Freedom Forever
Planset Revision Letter

2/14/2024
REV #1

CATHERINE MEYER
332 DOCS ROAD , LILLINGTON, NC 27546

ROOF MOUNT PHOTOVOLTAIC SYSTEM

ROOF PLAN
 SCALE: 1/16" = 1'-0"

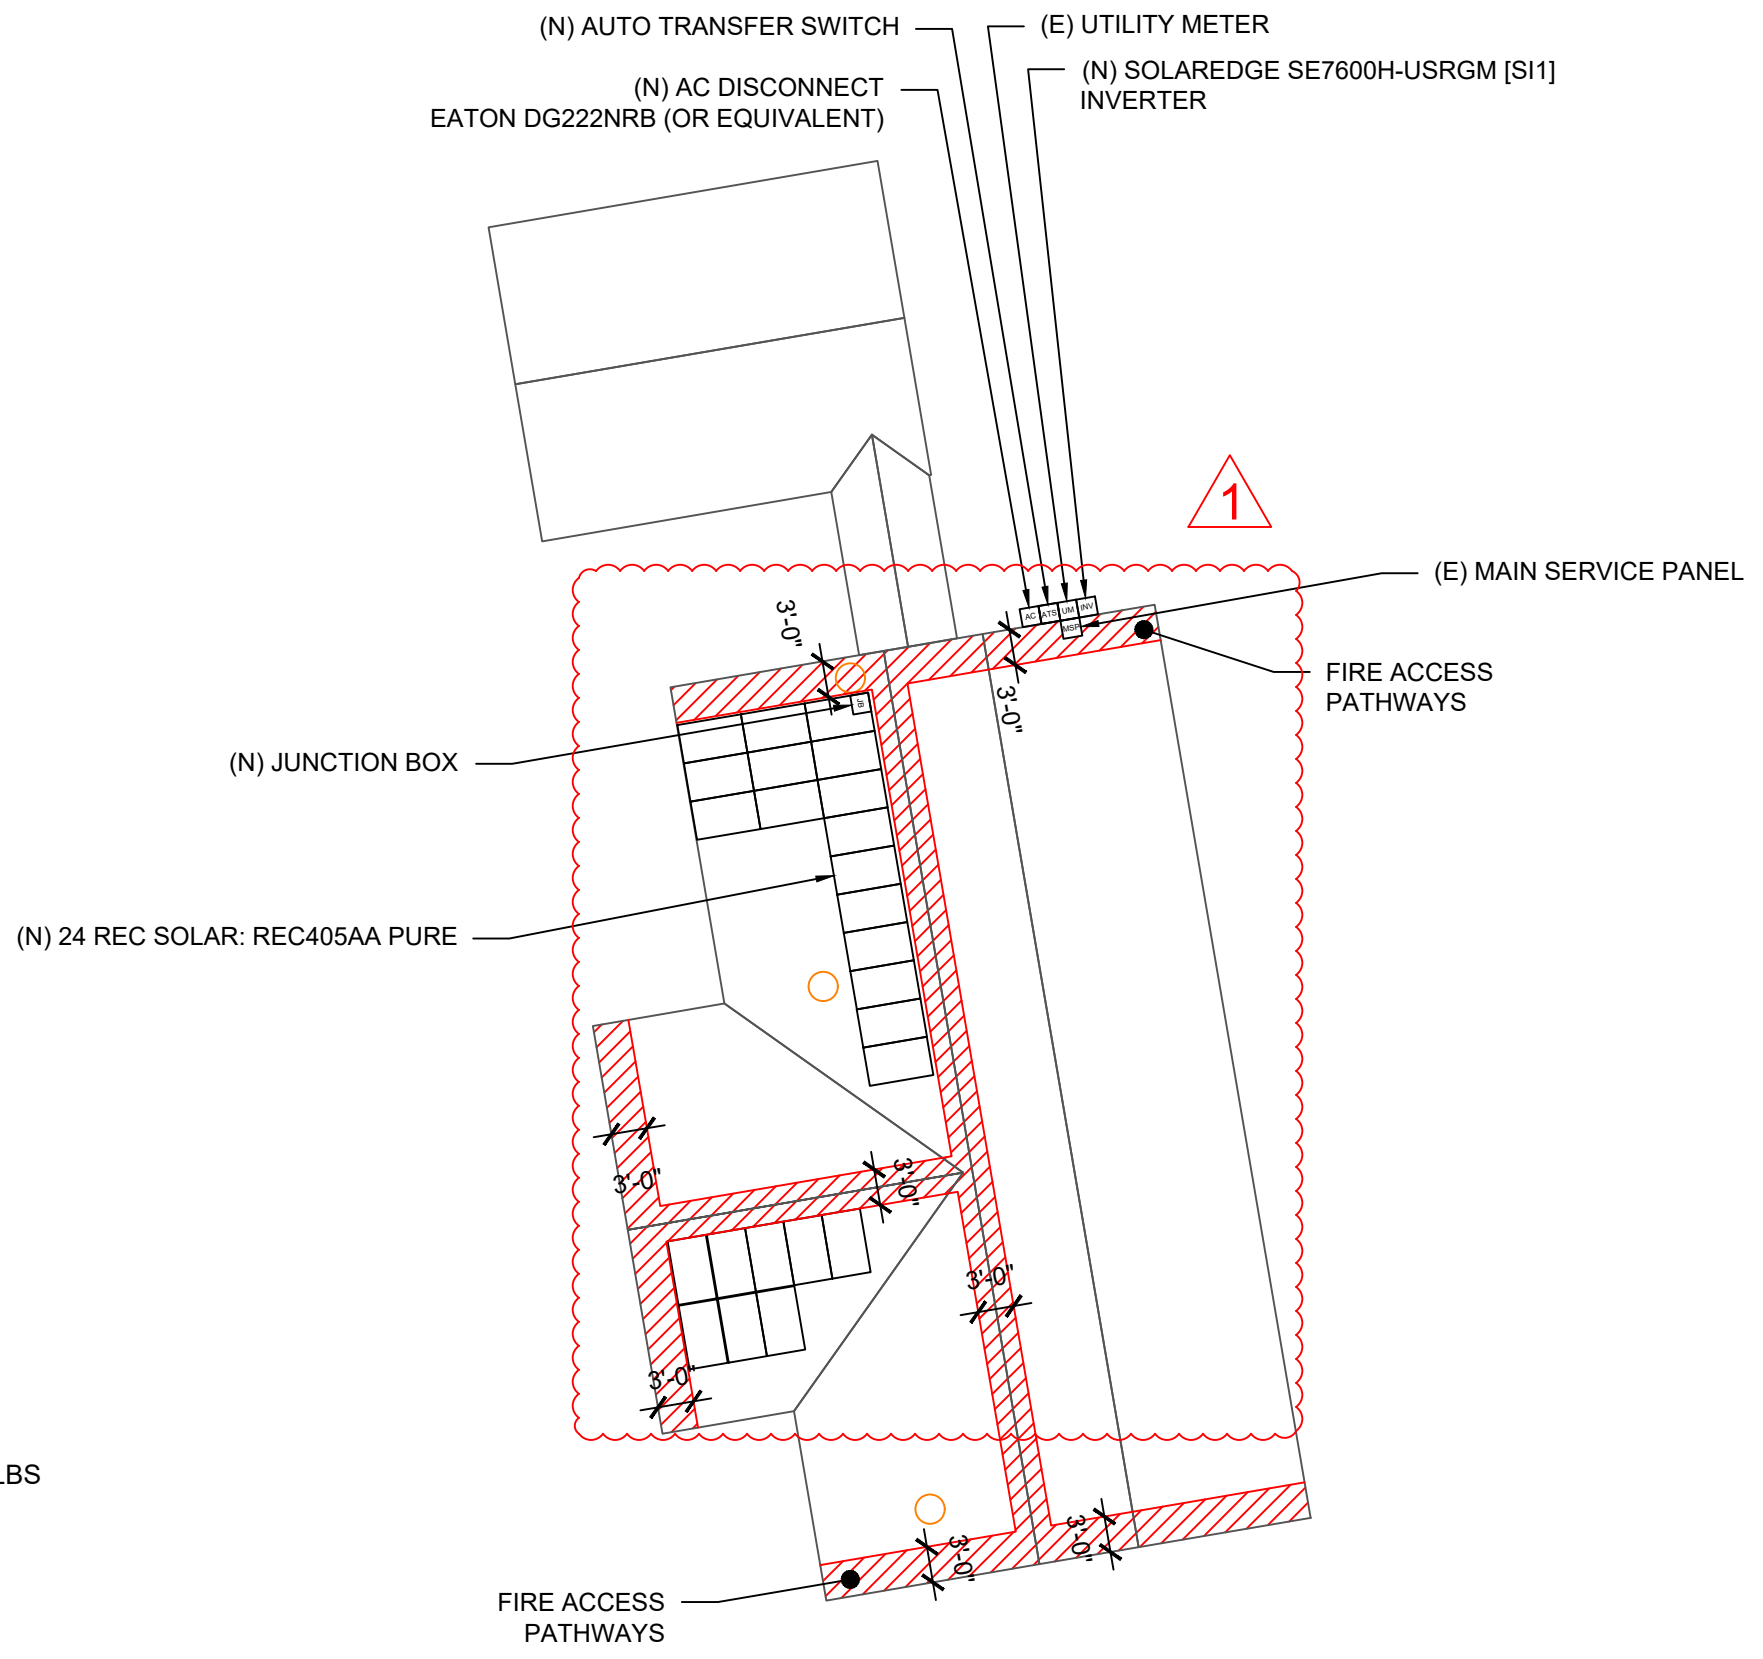
1. Layout updated

All corresponding changes are notated on the plans by revision clouds.
